**MAJOR PROJECT ASSESSMENT:  
7-9 Gibbons Street, Redfern  
(MP08\_0112 MOD3)**

Director-General's  
Environmental Assessment Report  
Section 75W of the  
*Environmental Planning and Assessment Act 1979*

November 2012

1 Level 04  
NTS

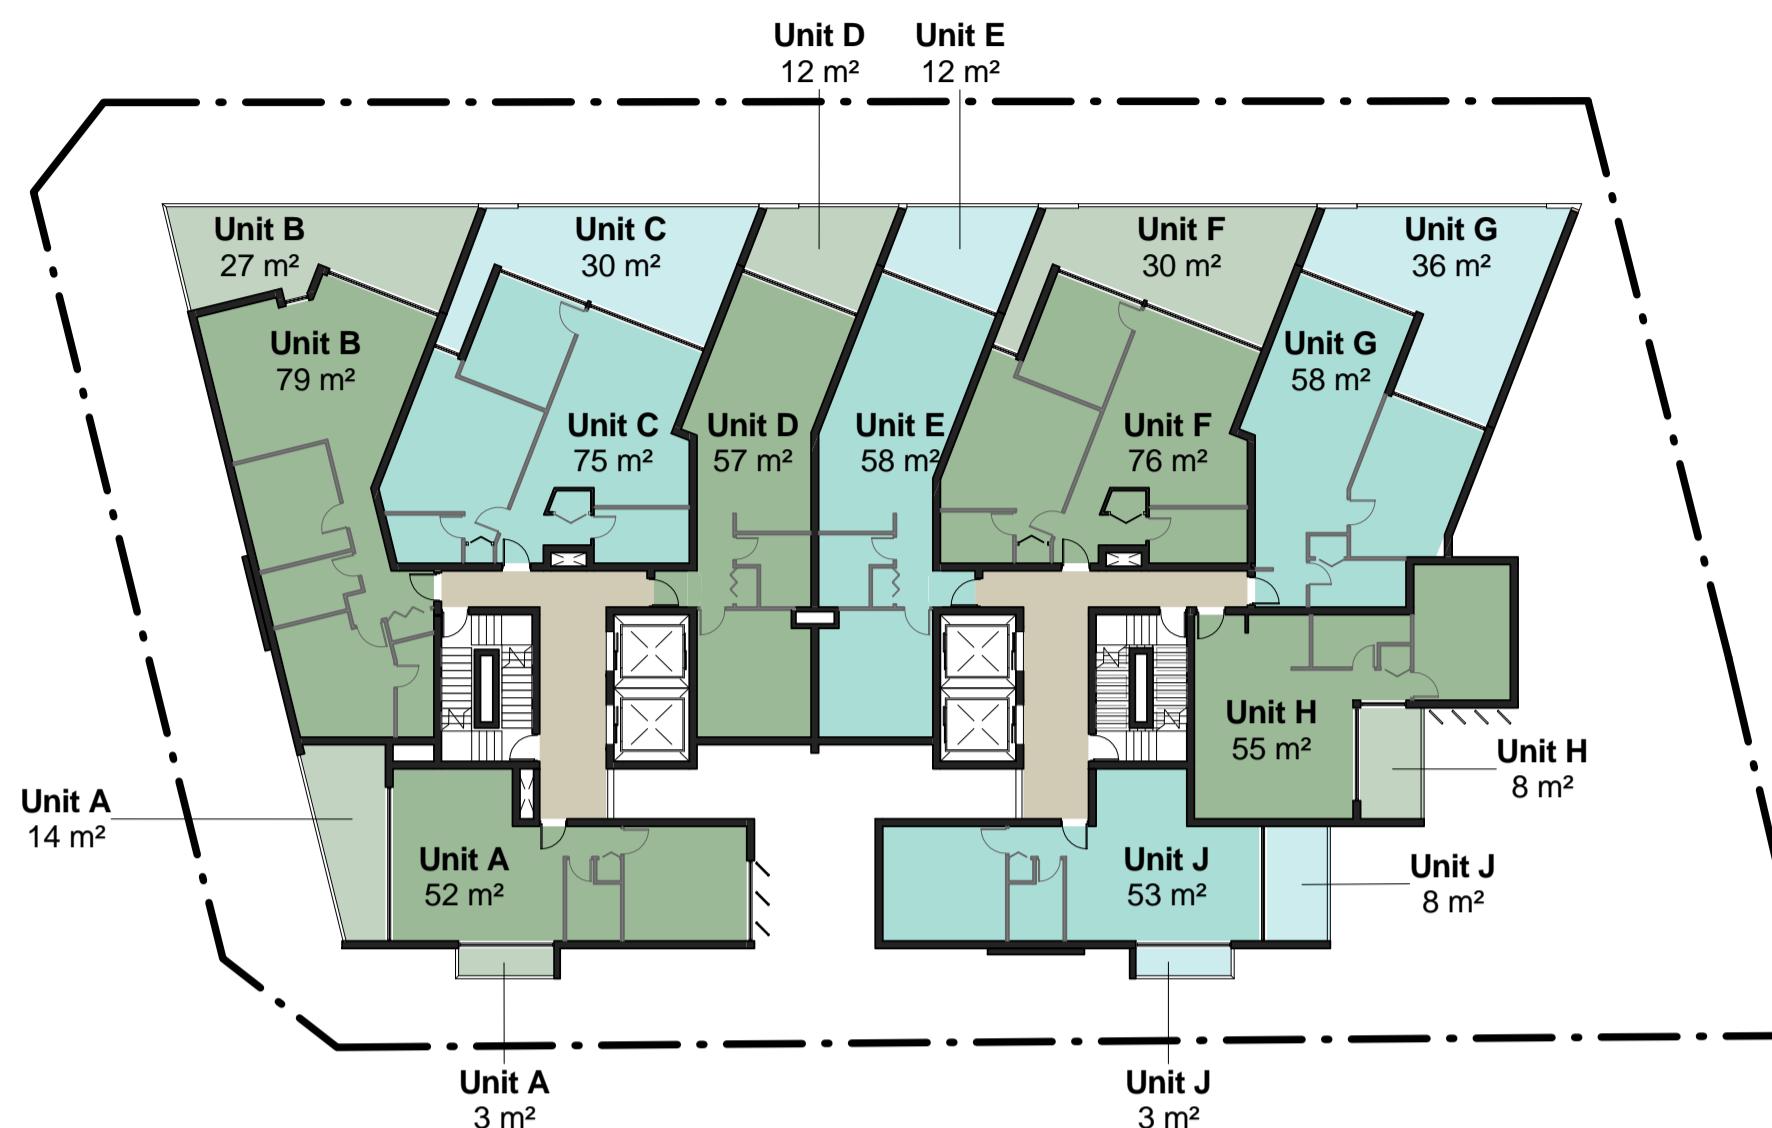
It is noted that the modification originally proposed an external plant area on level 04. The Department raised concerns with this on urban design and acoustic privacy grounds. Subsequently, the proponent relocated the plant internally to level 01.

Originally there were concerns the proposed location of the plant room on level 4 had the potential to result in adverse noise impacts within the subject building (it was located immediately adjacent to a unit).

As a consequence of this concern, the plant has been relocated to Level 01 (High Level), which substantially reduces the potential acoustic impacts to residents within the building at 157 Redfern Street and those within the subject building. In this new location, the plant would be located adjacent to void areas and stair wells as opposed to a residential unit.

PLAN OF: STRATUM SUBDIVISION OF
LOT 1 IN DP1164832

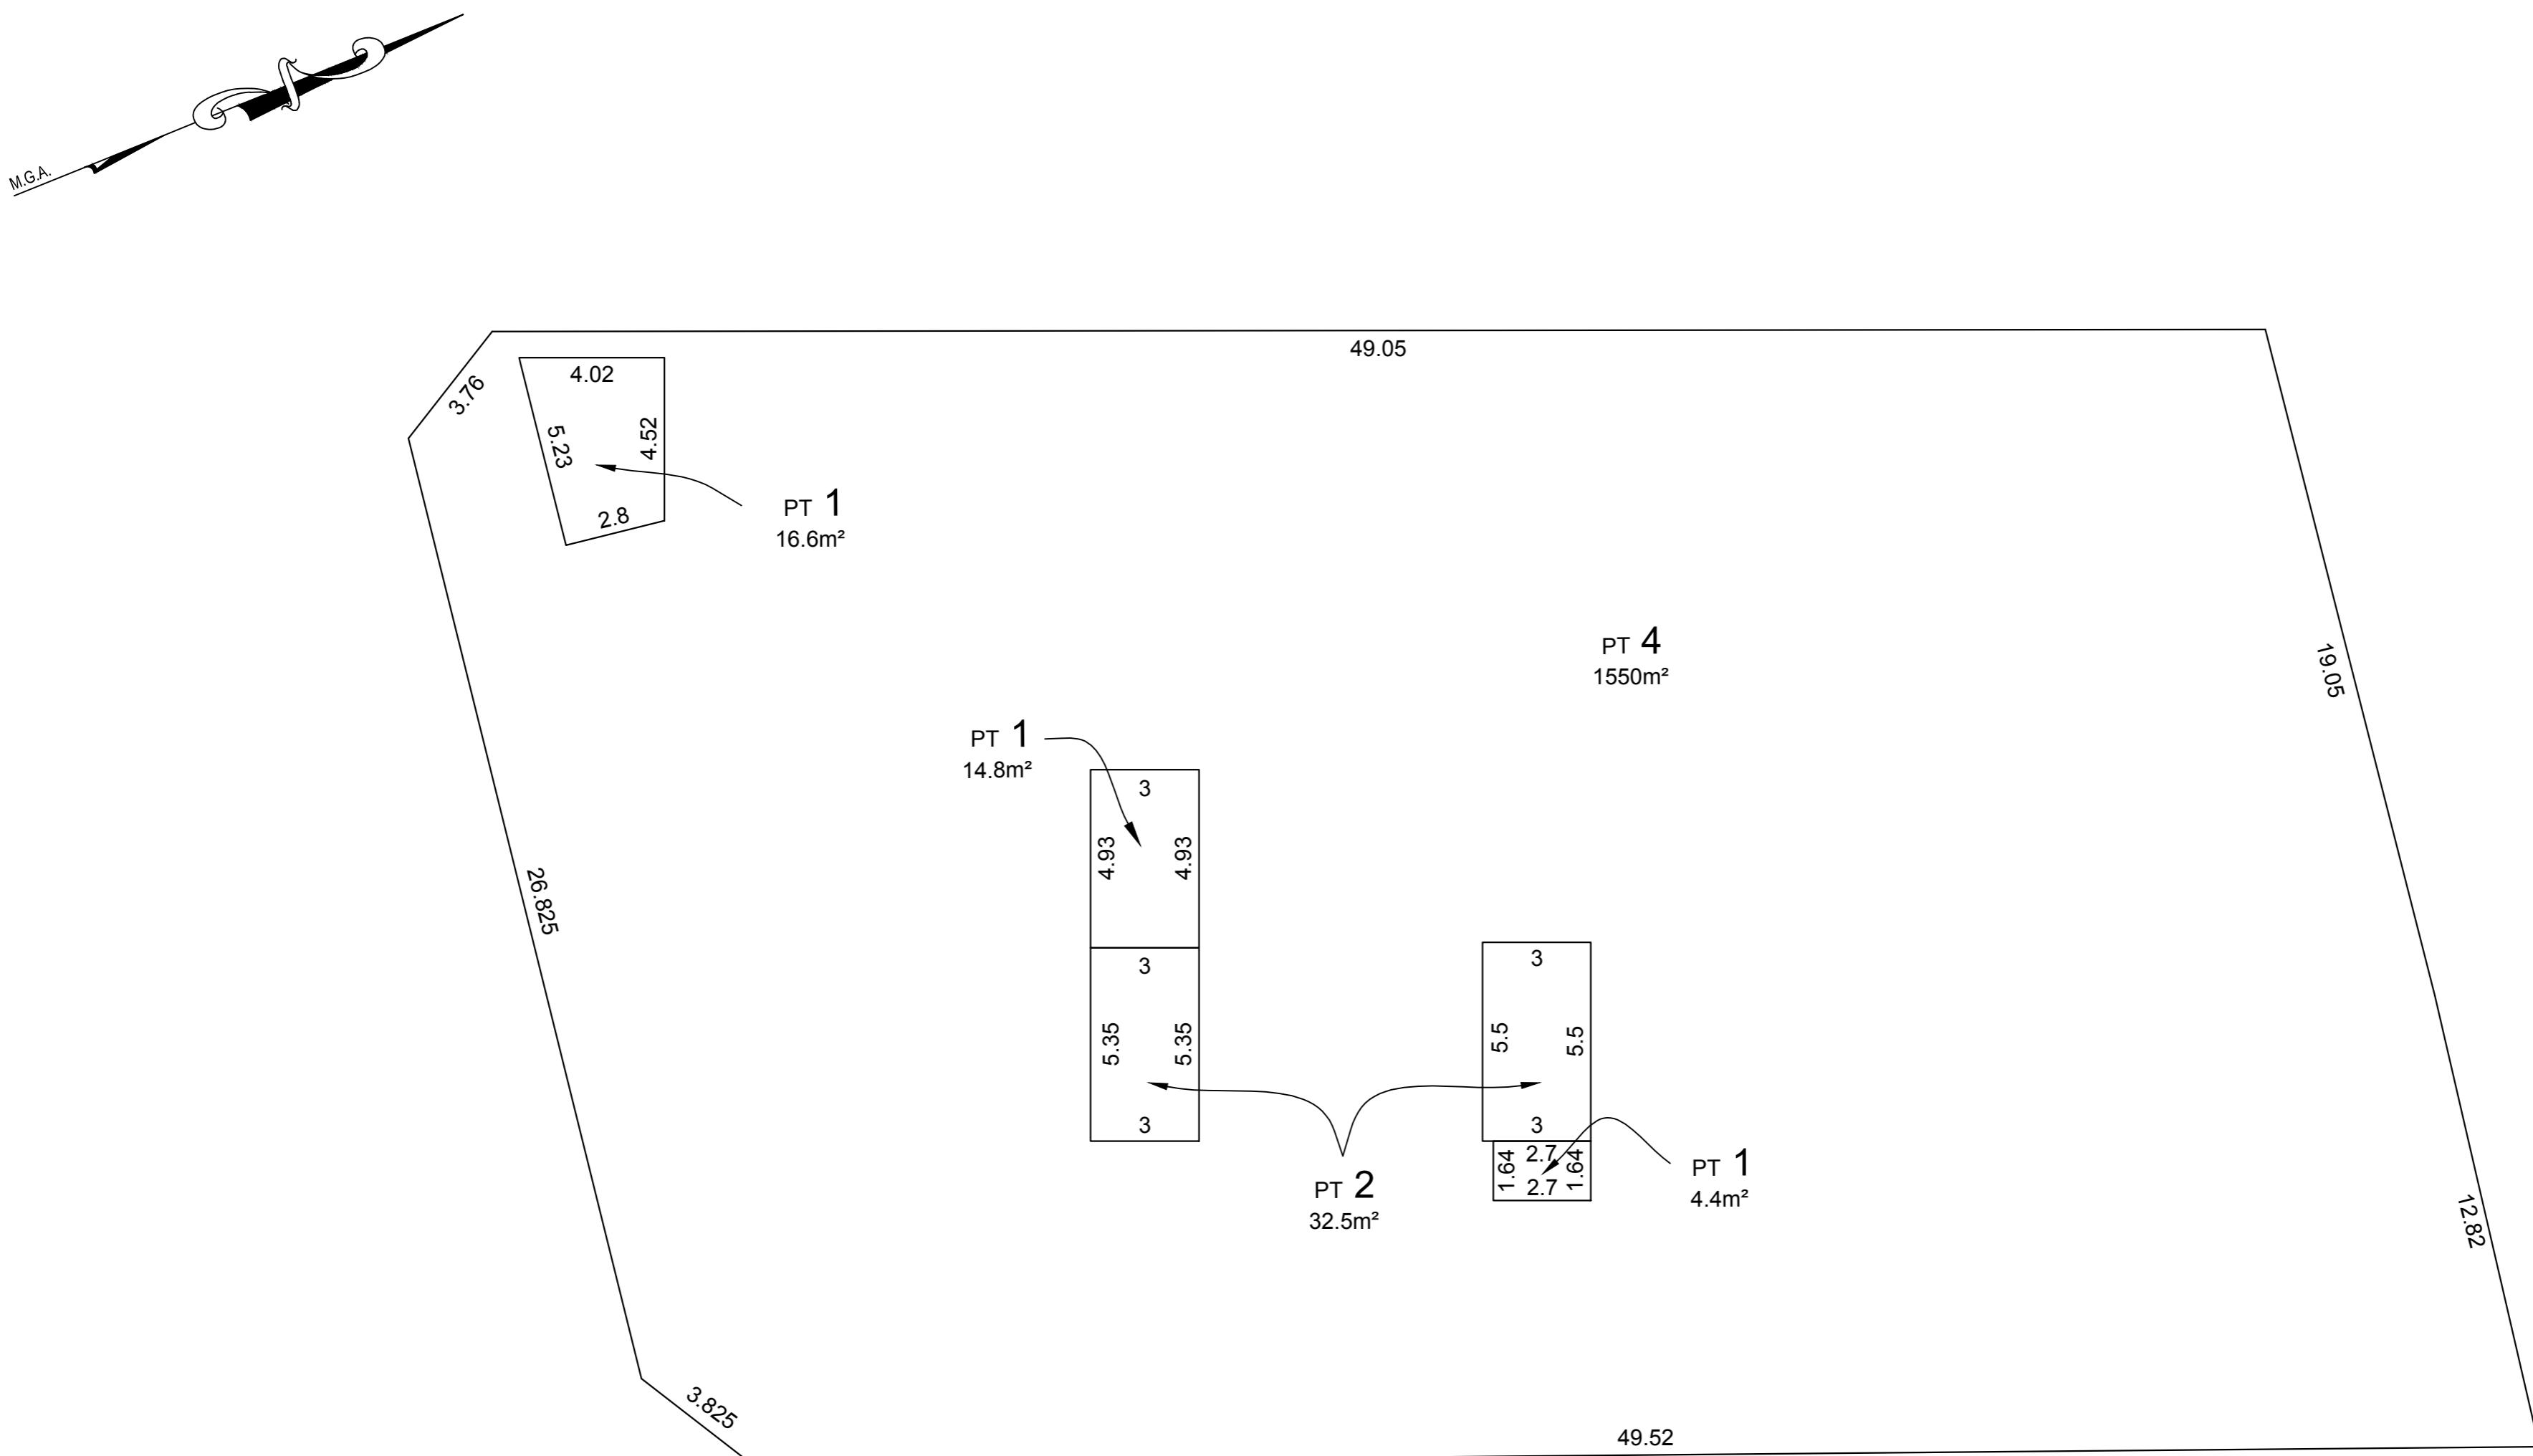
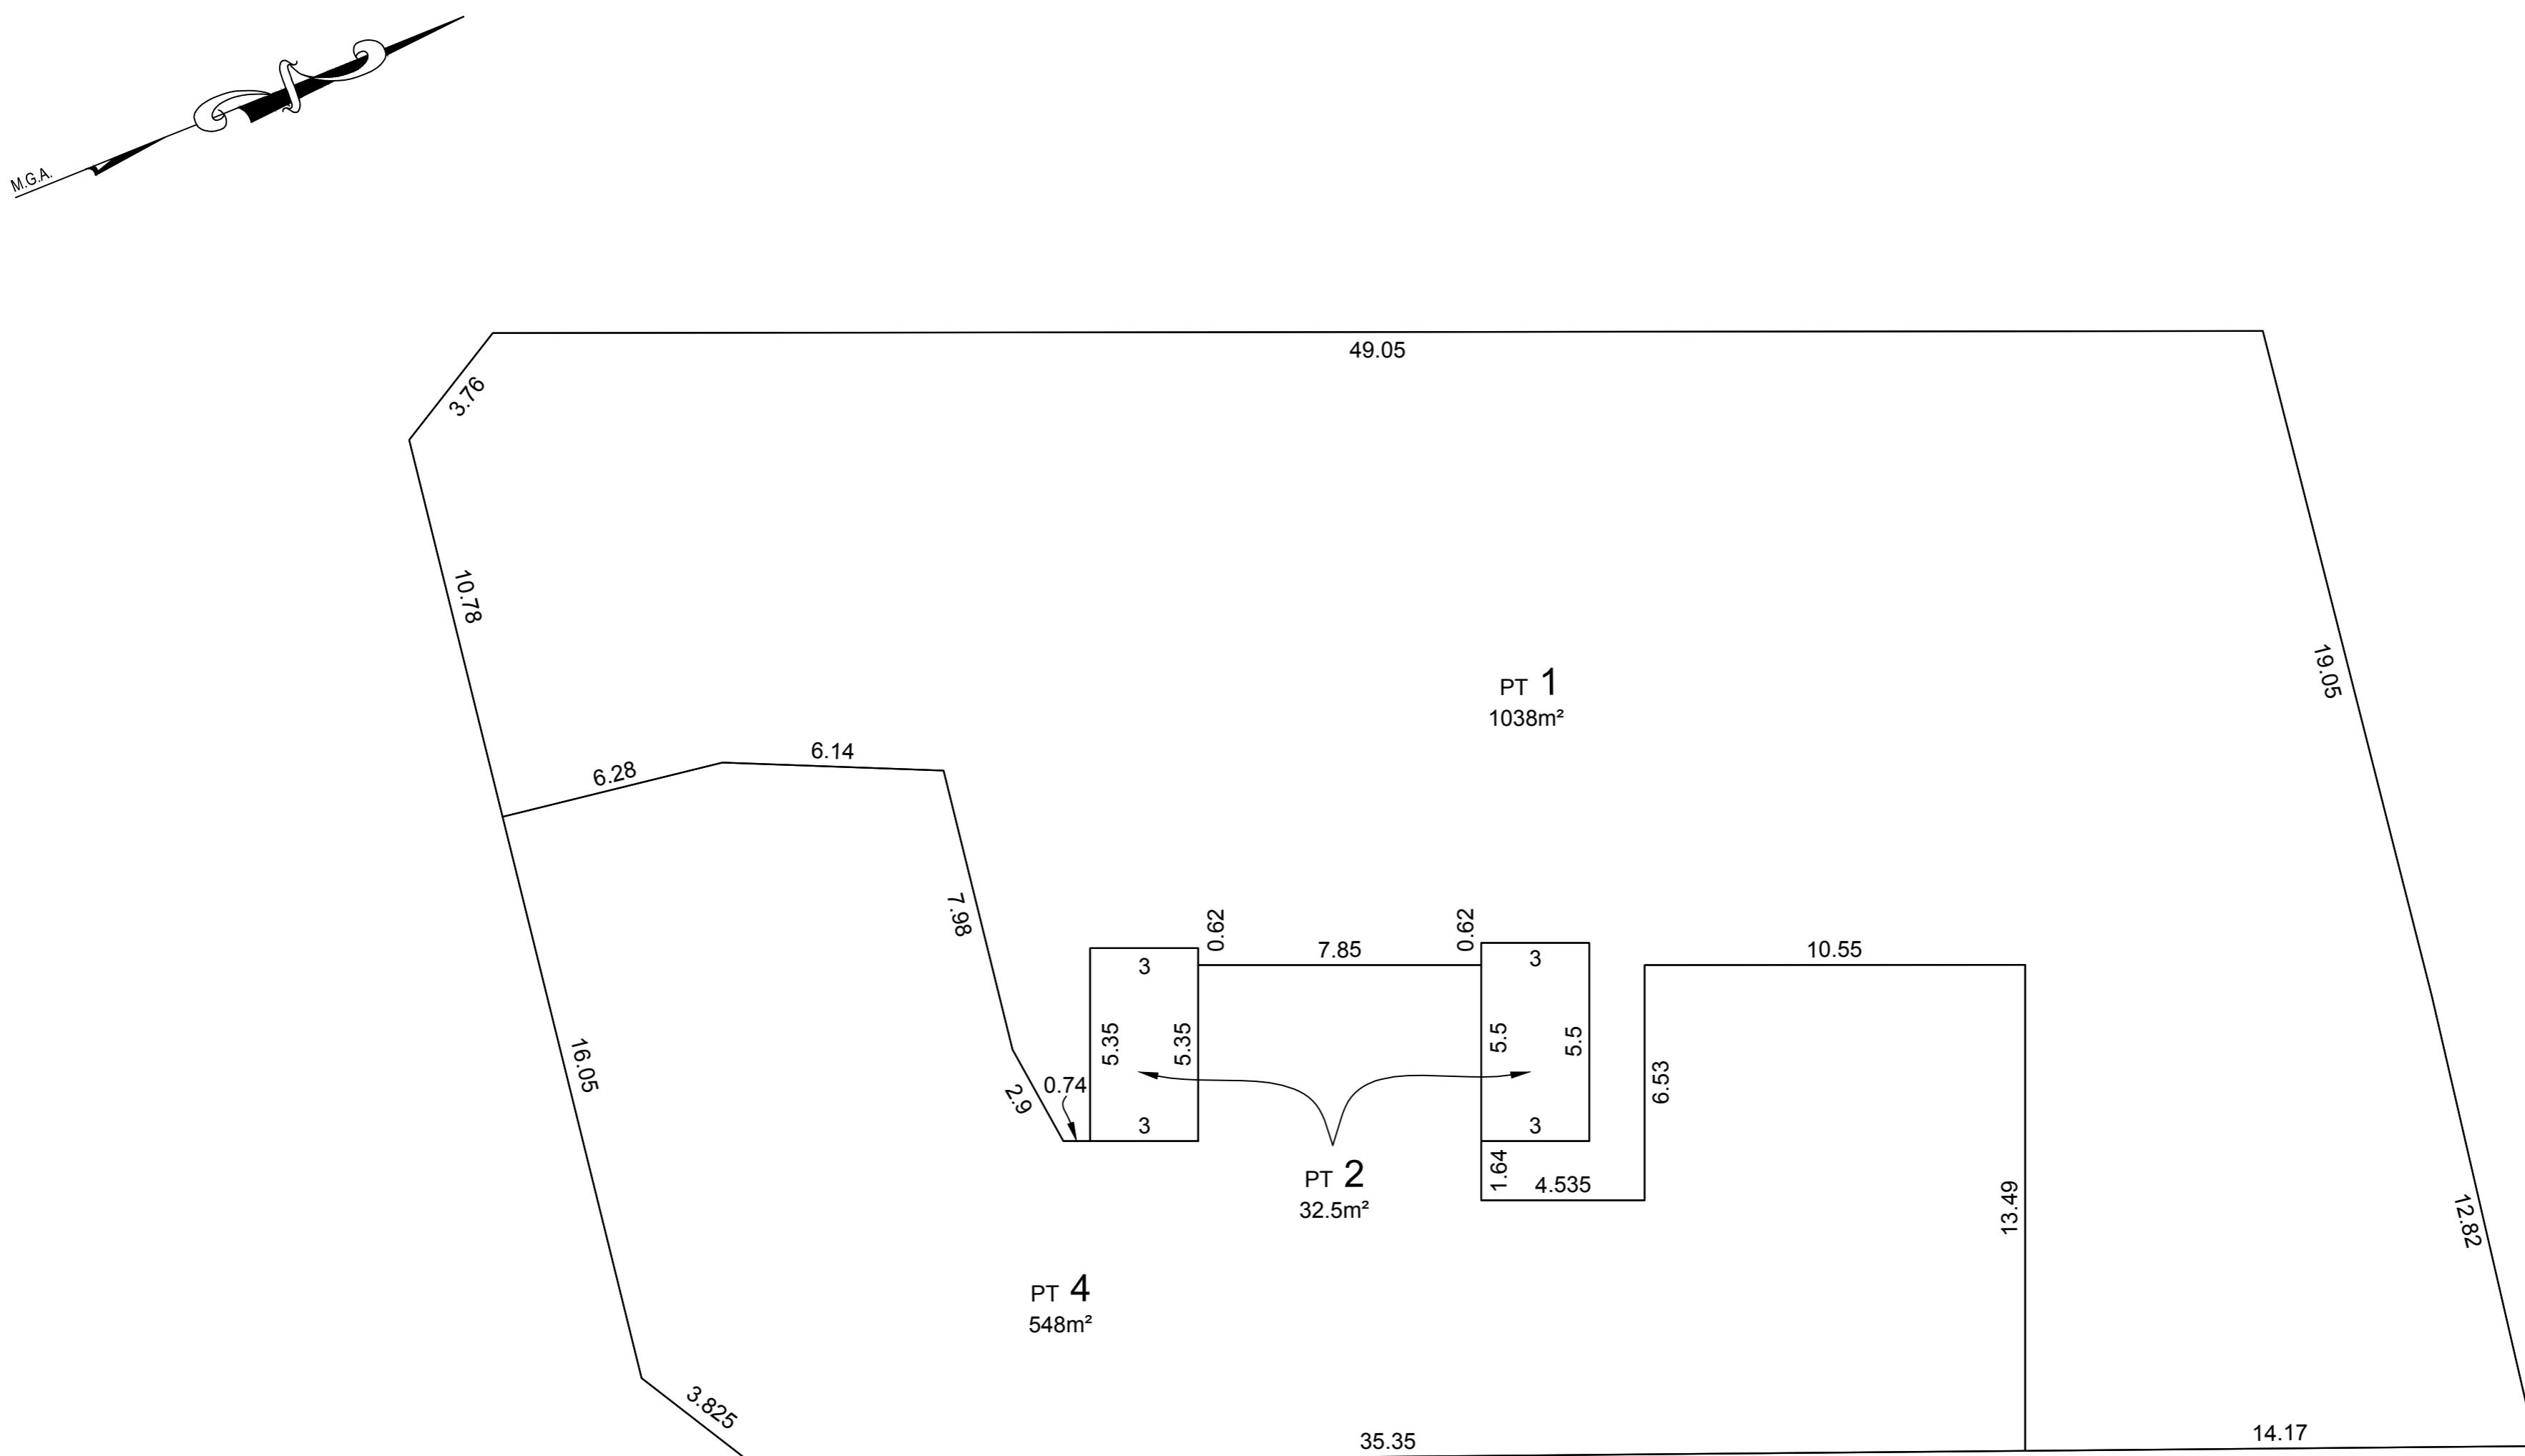
The modification request includes a draft stratum subdivision plan for the following allotments:

The Department considers the stratum subdivision to be consistent with the project approval and raises no issues in this regard. It is further noted that the draft stratum plan is generally consistent with the parking provision requirements contained in Condition A10 of the project approval. Although the specific number of car parking spaces allocated for each stratum lot have not been specifically nominated, the stratum subdivision does not preclude the requirement of the proposal to provide the car parking numbers listed in Condition A10. Therefore, the Department maintains confidence that the required number of car parking spaces will be provided.
